## DEVELOPMENT REVIEW BOARD

### Parks and Recreation Department

PR-2021-005210, SI-2021-00303 – SITE PLAN, CONSENSUS PLANNING INC./CHRIS GREEN, PLA, ASLA agent for ALBUQUERQUE DEPARTMENT OF MUNICIPAL DEVELOPMENT/PATRICK MONTOYA, DIRECTOR requests the aforementioned action(s) for all or a portion of C3A, WESTLAND NORTH, zoned PC, located at 1801 ARROYO VISTA BLVD NW between 118T ST and 1801 ARROYO VISTA BLVD NW containing approximately 81.2 acre(s). (J-7 & 8)

REQUEST: ADDITION OF A SIXTH ATHLETIC FIELD AS PART OF PHASE 2 OF THE ALBUQUERQUE REGIONAL SPORTS COMPLEX

TITLE:
SITE PLAN

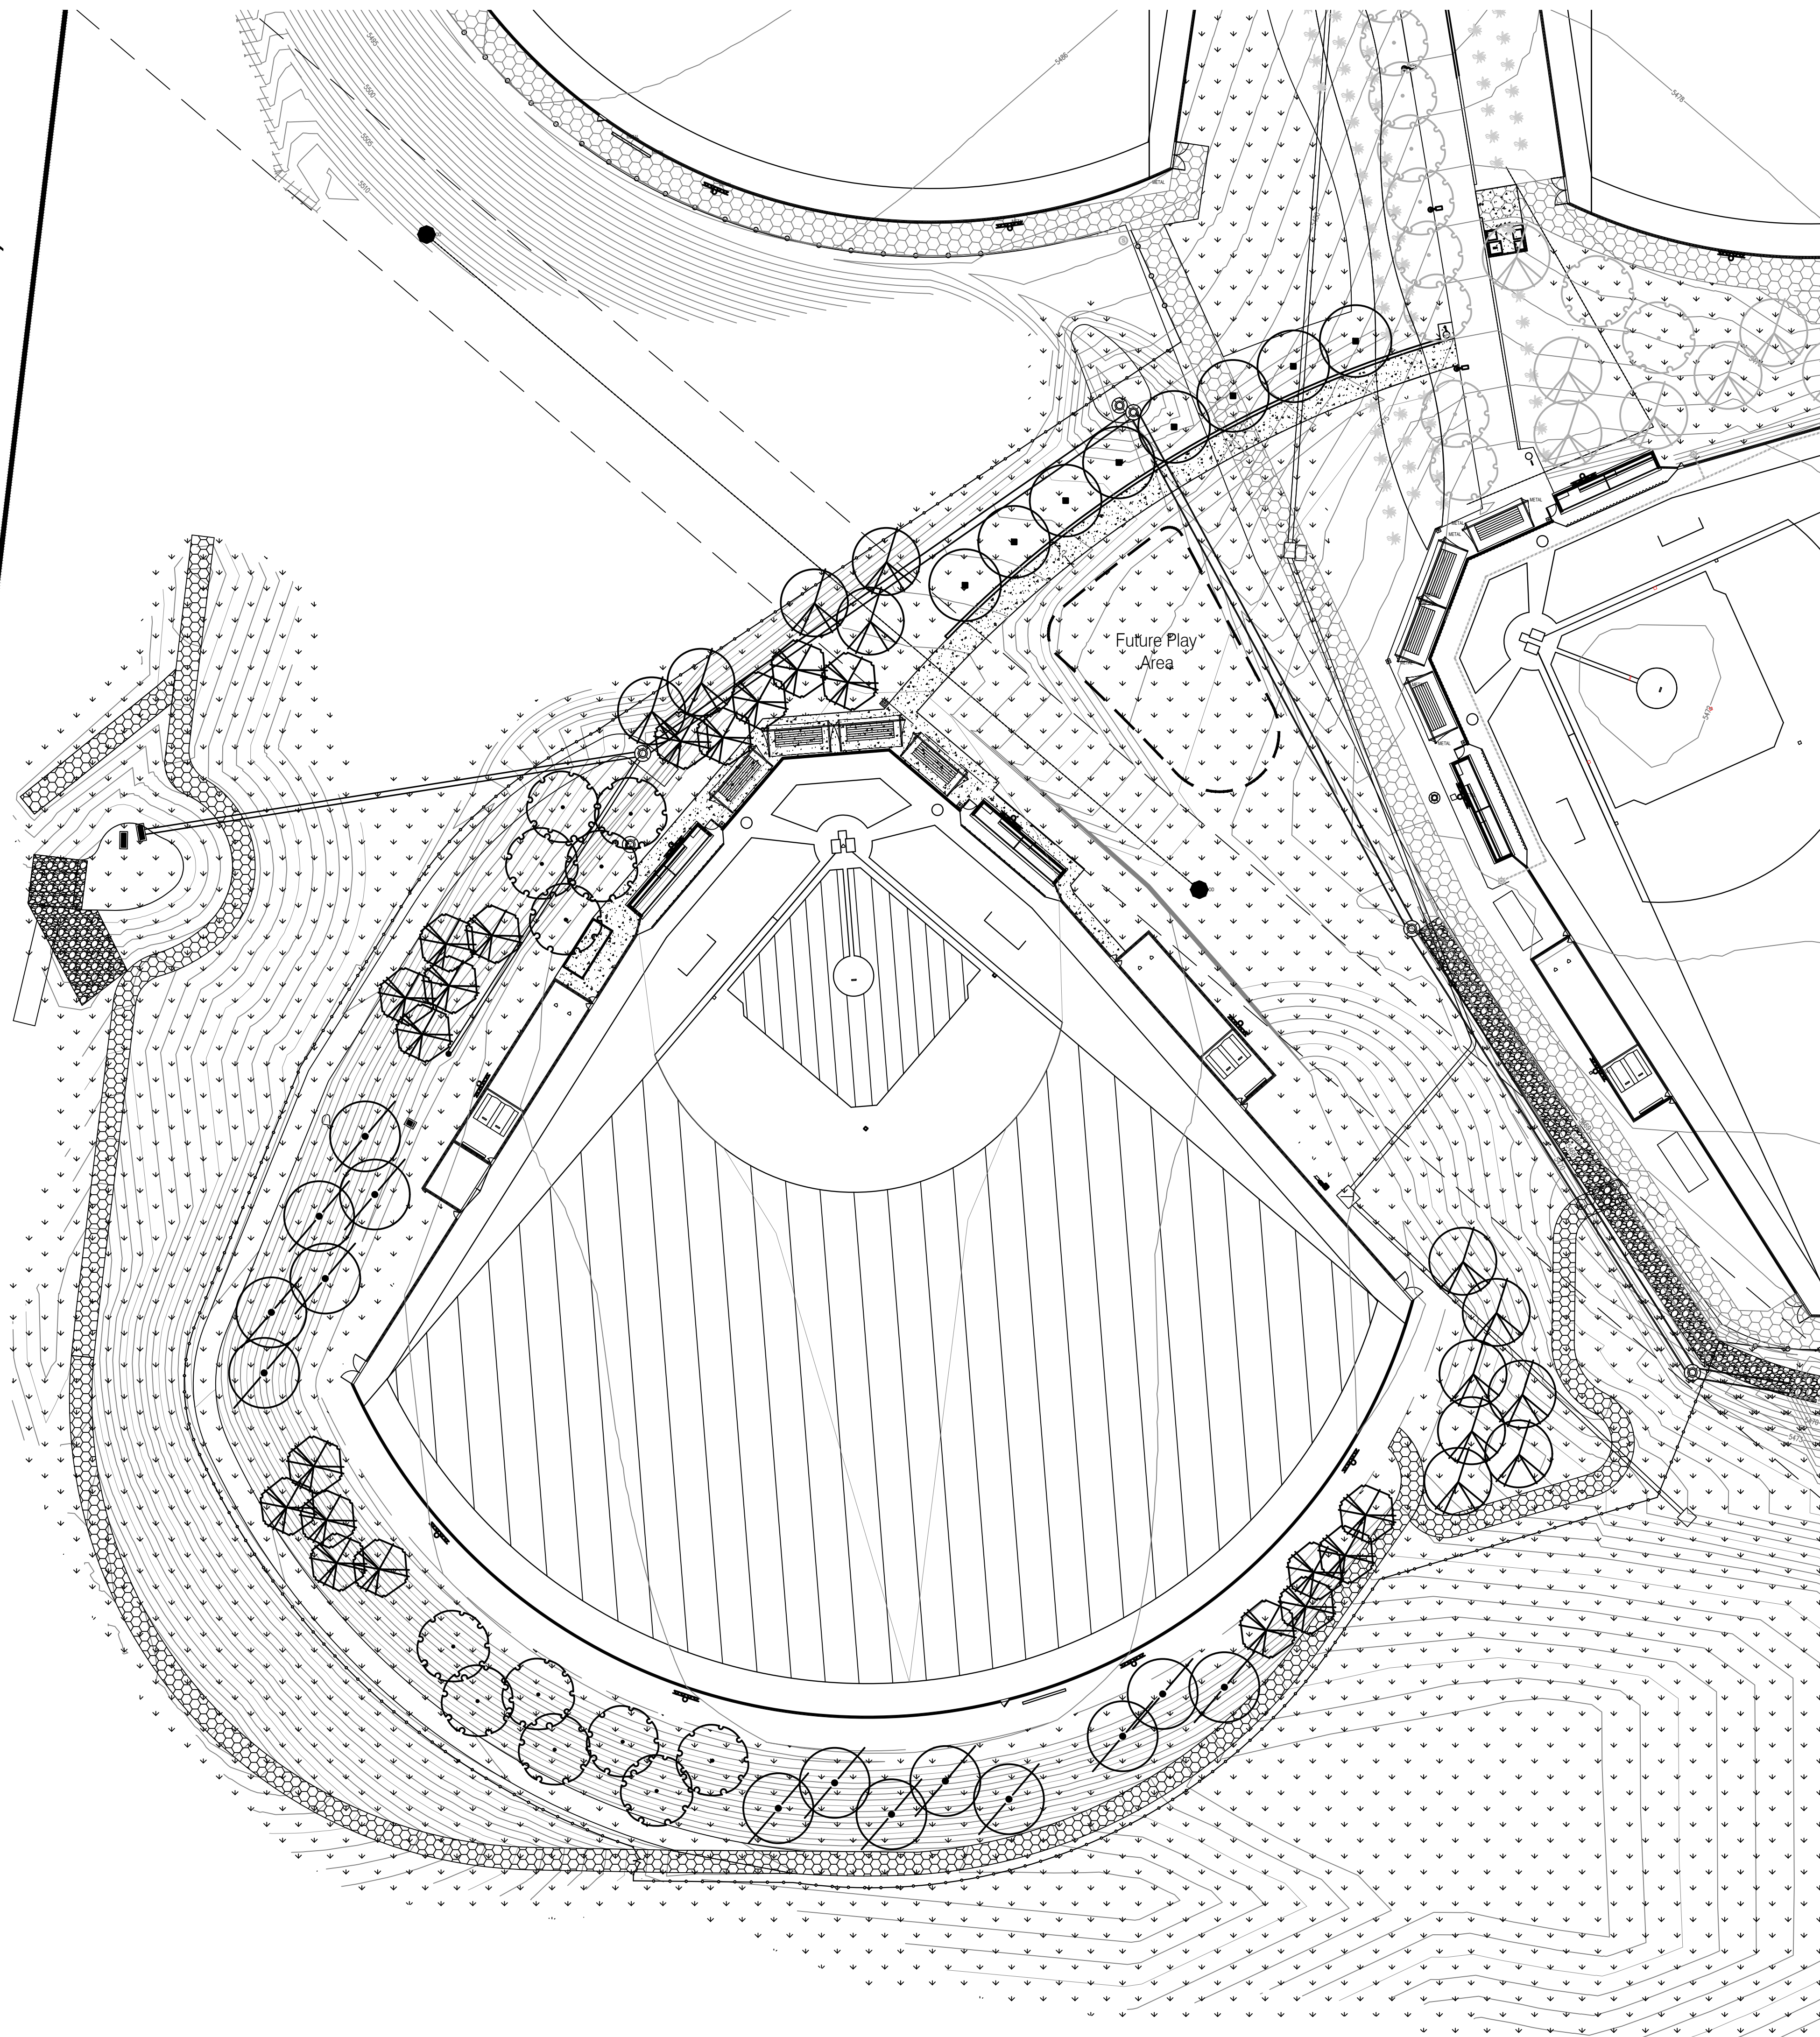
PRD is aware of the proposed addition of a 6<sup>th</sup> field at the Westside Sports Complex. The MTP 2040 shows a Proposed Multi-Purpose Trail on the subject site. This can be accommodated in a future phase. 118<sup>th</sup> St is not yet constructed, therefore street trees can be accommodated in a future phase as well. Major Public Open Space is located across 118<sup>th</sup> to the west. Please contact the Open Space Division if construction is expected to encroach.
